Ref. No: 260-280 Edward Street
Contact: Cameron Collins

**PROJECT APPLICATION – STAGE 1 AND 1A OF THE REDEVELOPMENT
OF WAGGA WAGGA BASE HOSPITAL, EDWARD STREET, WAGGA
WAGGA**

Your Reference: MP No. 11_0087

FIGURE 01: Typical Section Through New Lewis Drive

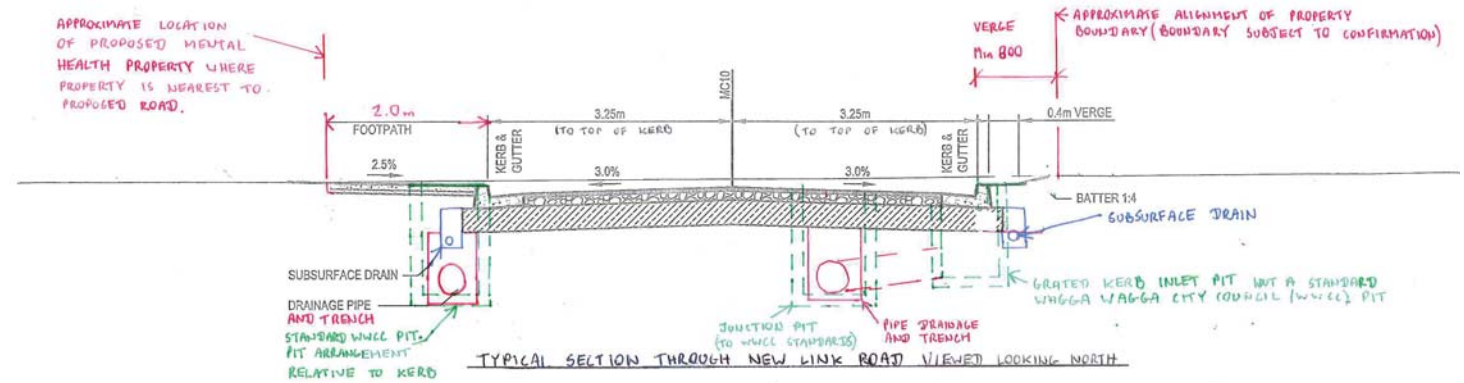
24. The proposed new Lewis Drive shall have a 6.5m wide carriage way between face of kerbs, 0.4m wide nature strip on the eastern side and

2.5m wide nature strip on the western side. Street lighting shall be included and constructed to the relevant Australian Standard.
